From: Anita Gardner <Anita.Gardner@arun.gov.uk>
Sent: 14 May 2020 15:03
To: Planning.Responses <Planning.Responses@arun.gov.uk>
Subject: FW: LU/107/20/PL - 15 Beach Road, Littlehampton

From: [Anita Gardner](#)
Sent: 12 May 2020 18:55
To: [Graham Nicolls](#)
Subject: LU/107/20/PL - 15 Beach Road, Littlehampton

- 1) There are areas on the first and second floors where the letter "W" is written. What does this mean? Wall?
- 2) The applicant has proposed to site the entrance door to the internal communal staircase, located at ground floor level in the entrance road to Manor Car Park. The road itself is rather narrow and to have a residential doorway opening onto it would seem unsafe without a paved/guarded area to exit/enter onto to. My thoughts are that perhaps keeping the external stairs would be a safer option, but I appreciate Flat A wouldn't then have exclusive access to the roof terrace.

SCALE / 1:100 @ A3
DATE / 22.03.2017
DWG. NO / 080616 / TP.02 'A'

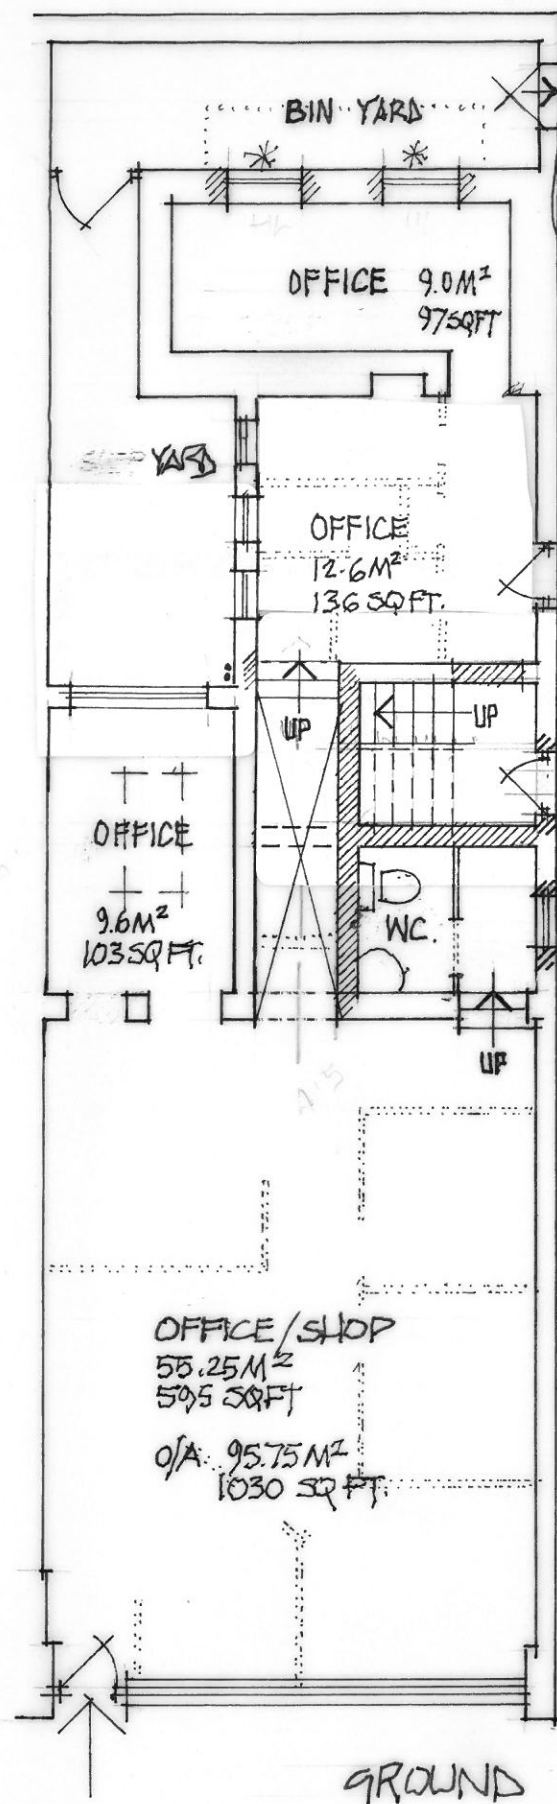
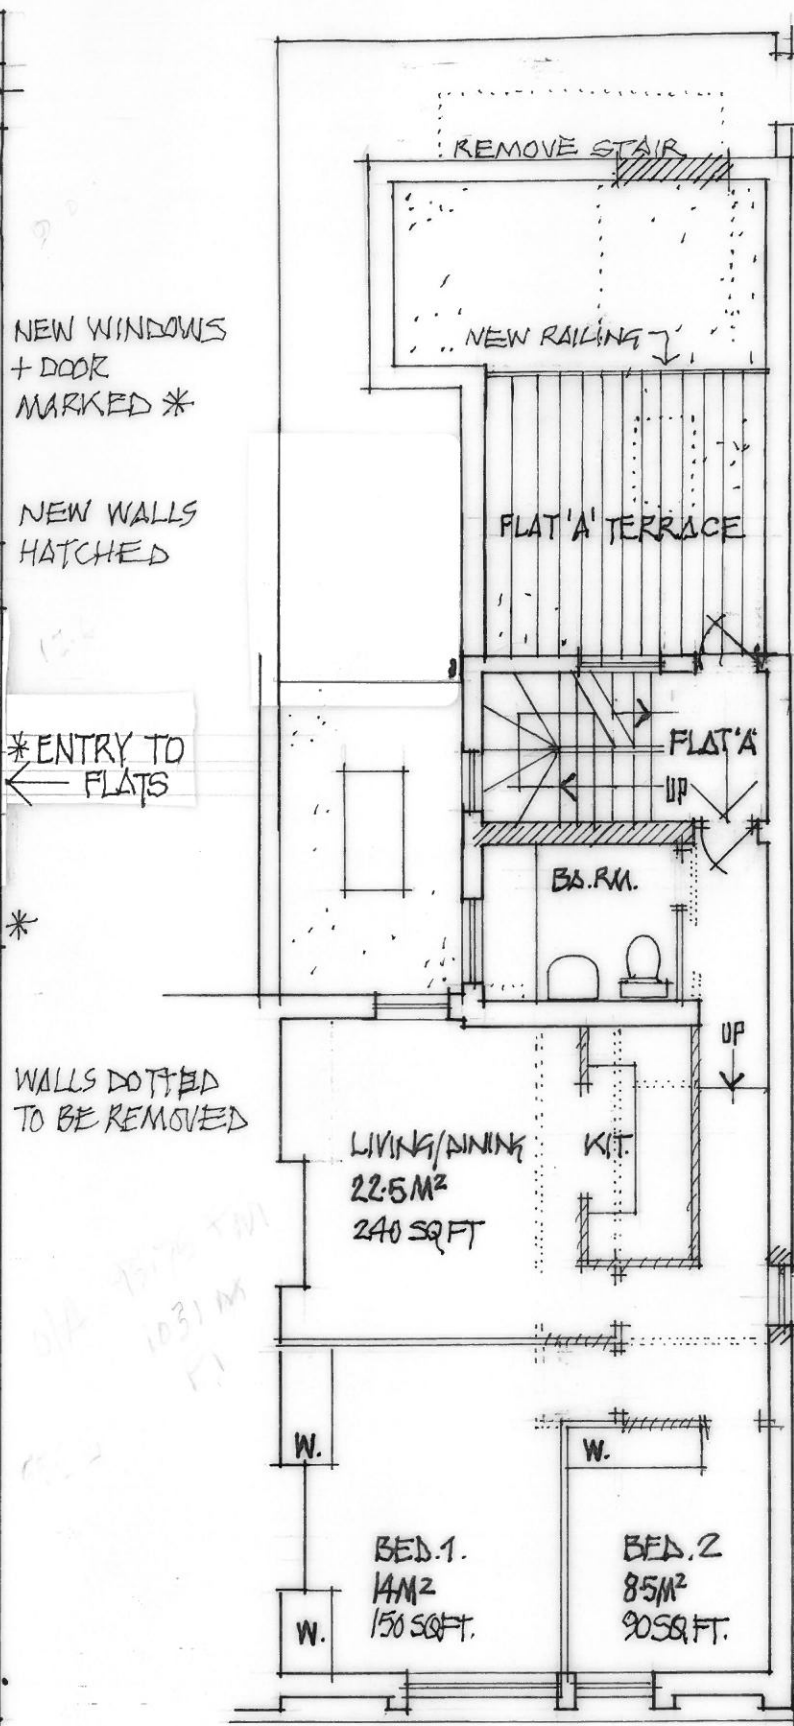
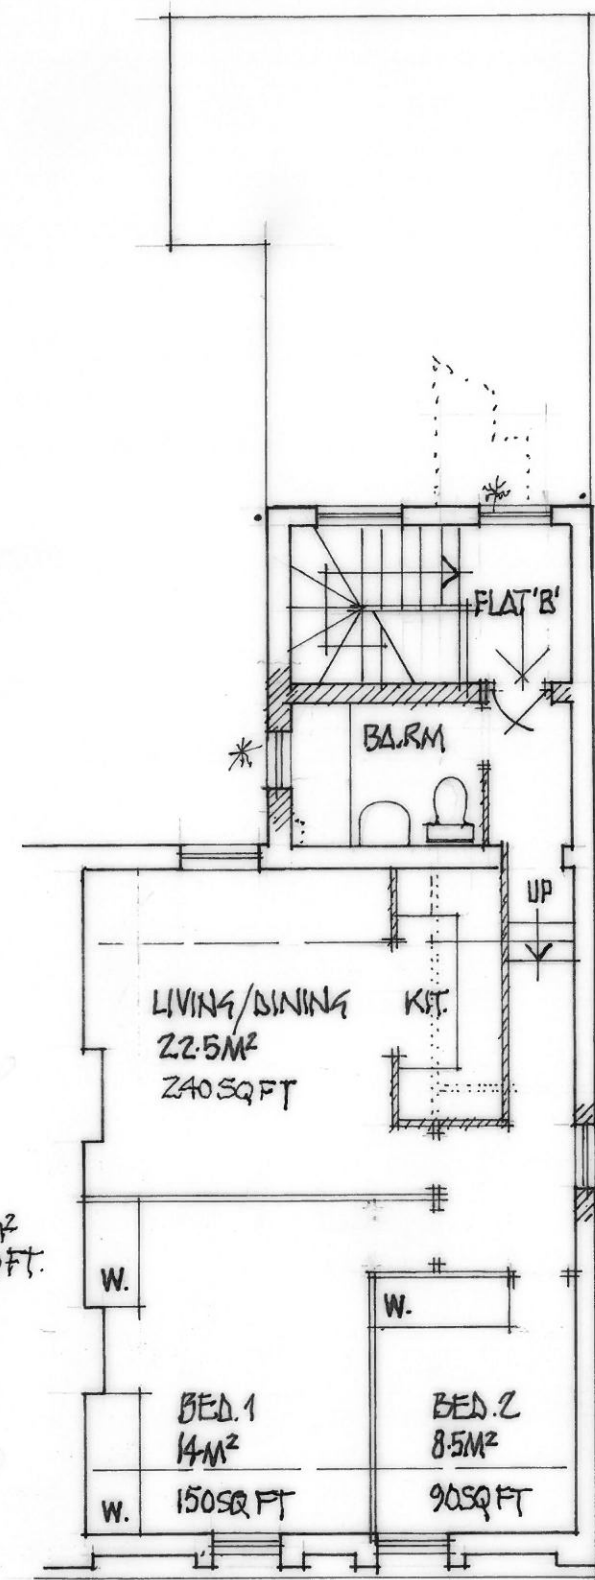
- 3) There is no mention of a fire alarm system and what fire-resisting separation there is between the commercial and domestic areas.
- 4) Internal doors are not annotated on the plans supplied for the flats.

1. The letter 'W' on the plans indicates a wardrobe.
2. I attach a revised version of the Planning Statement with a new item 12 stating that of course all Building Regulations will be complied with and consent obtained. Details will form part of the future Building Regulations application.

3. The existing side access to the offices and the rear yard gate both open onto the vehicle access at the side of the property. The door is slightly relocated but the same situation is retained. Currently office staff numbers are approximately the same as will be the case when the new residential use is established. The door and gate both open inwards which is normal and does mean that egress is slowed down due to the action of opening them before stepping out. We could apply for permission the place a bollard each side of the door but this may require Arun D C consent. [See attached sketch]

PROPOSED ALTERATIONS TO FORM 2 NEW TWO BEDROOM FLATS

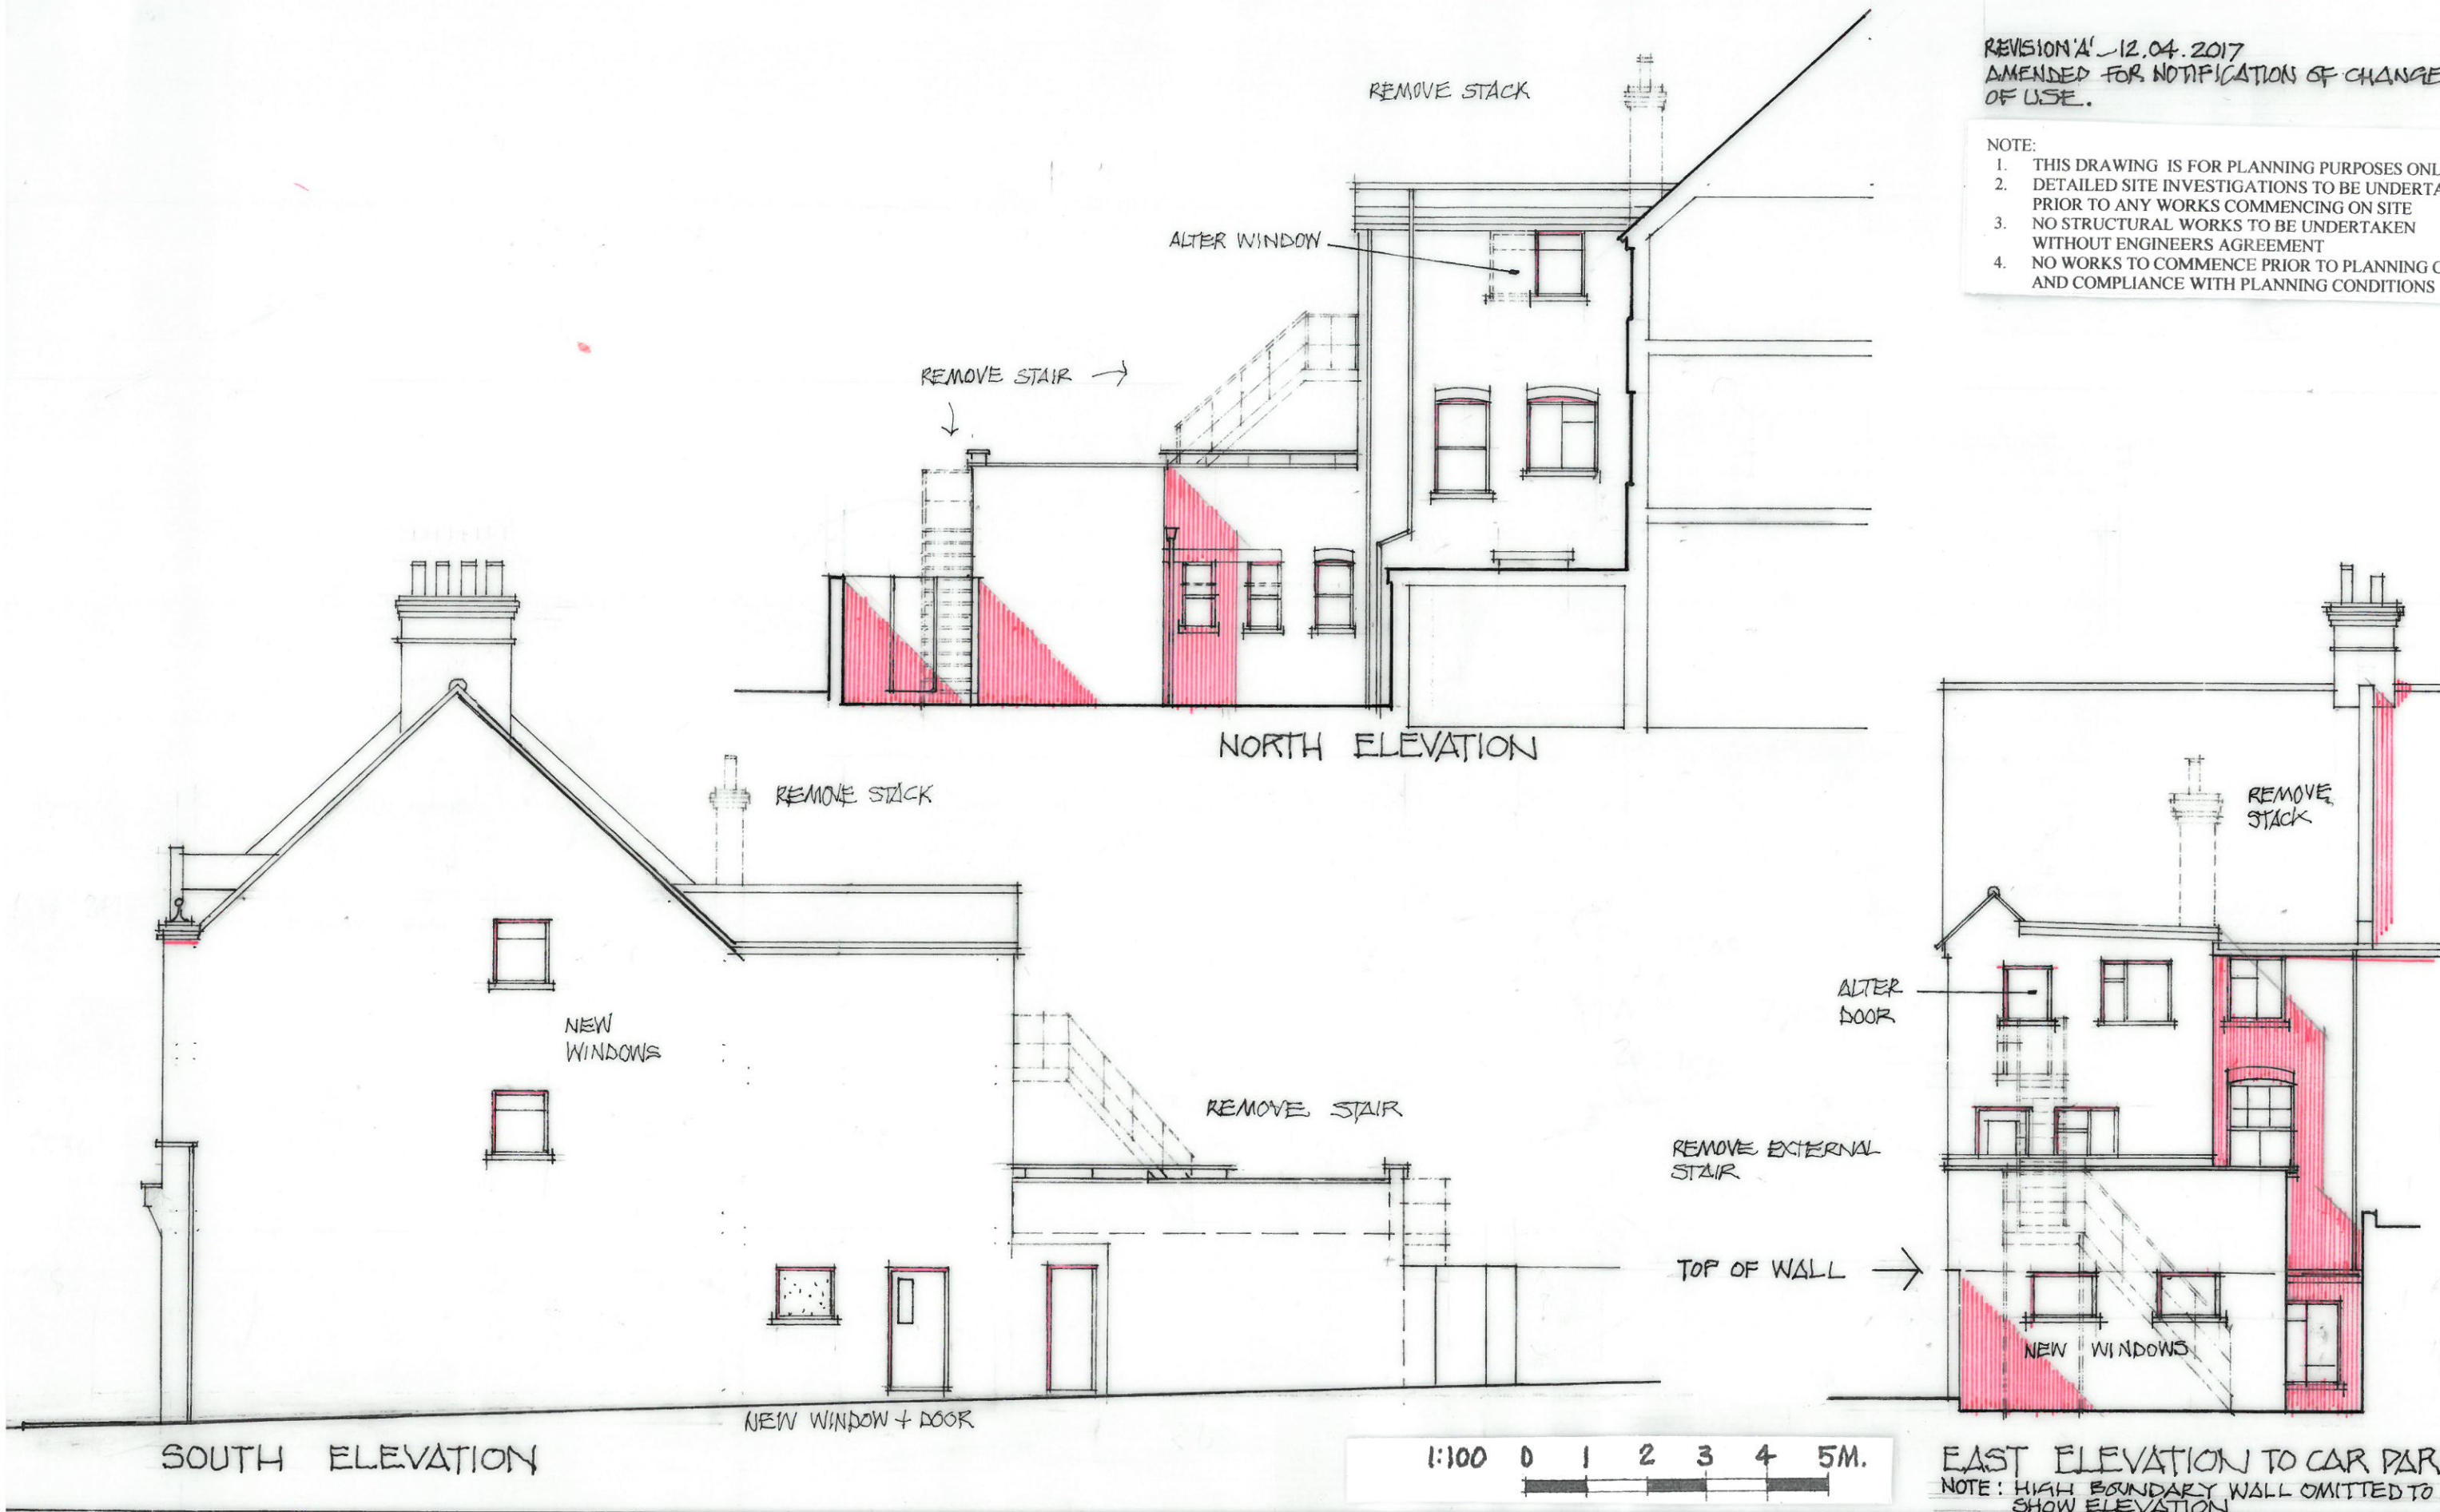
- 5) Railings to the Flat A roof terrace have been proposed, but no detail of height and type have been provided.

Dear Anita, the same applies to the proposed balustrading, this also has to meet Building Regulations and structural requirements and would also require Building Regulations consent. To an extent we need to open up structure to ascertain fixing points to achieve the required lateral restraint, the height would be 1100 as is normal.
